**Planning Act 2008: Applicant's Section 51 Response**

**Application ref: EN010147**

**Application by Photovolt Development Partners (PVDP) on behalf of SolarFive Ltd (the Applicant) for a Development Consent Order for Botley West Solar Farm**

Title: Works Plans Sheet 7 of 13

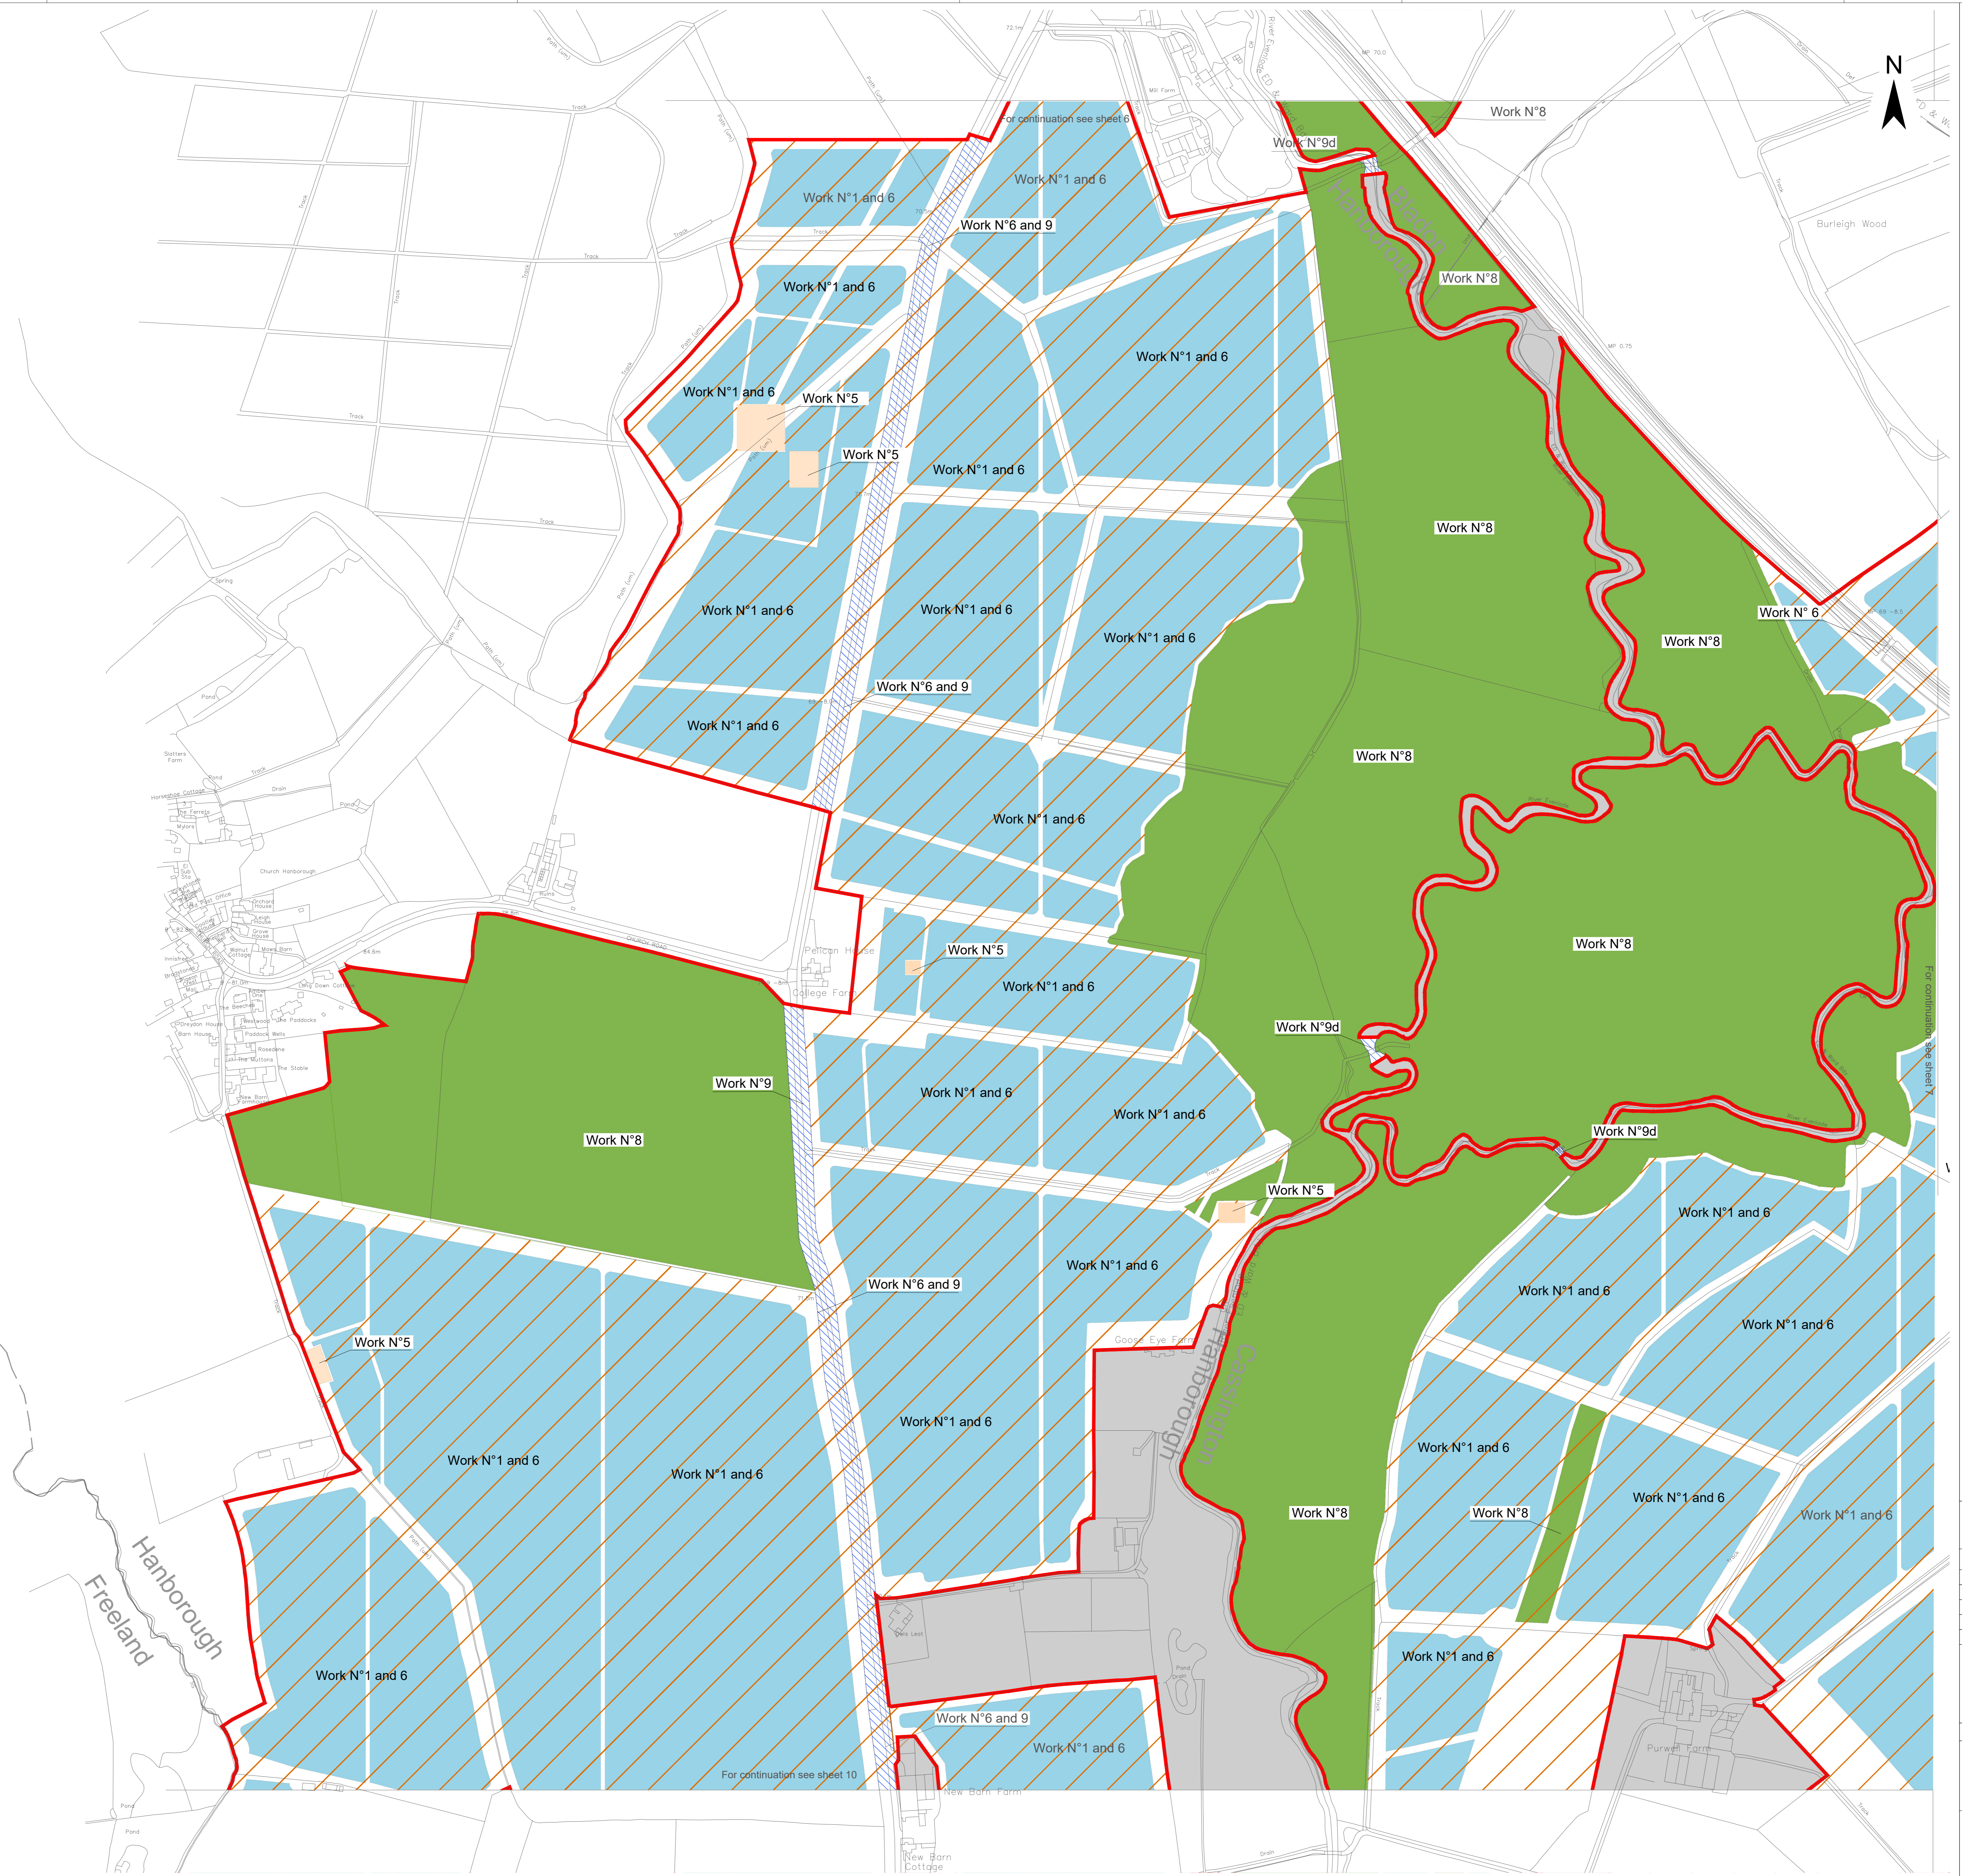
The Applicant has removed a small area of land (plot 6-17) amounting to 0.015 ha from its redline boundary. The area affected is shown in the ‘Project Refinements Plan’ at Appendix A of this Cover Letter and has also been reflected in each of the new and updated plans submitted alongside this s51 Response. For example, see Sheet 6 of the updated Land Plans and the updated Works Plans.

The reason for the reduction is to remove a vehicular access point that was initially designed to be used for construction and operation, in favour of using an alternative existing vehicular access further south. However, the landowner of plot 6-17 does not wish for the Applicant to use this access point and so, following further landowner engagement, the Applicant is willing to remove this plot from the Project. The Applicant will use the

alternative vehicular access further south, which will still allow unimpeded access to the norther most field using breaks in the existing hedgerows. This access has the added benefit of avoiding further hedgerow loss that may otherwise arise if plot 6-17 was retained.
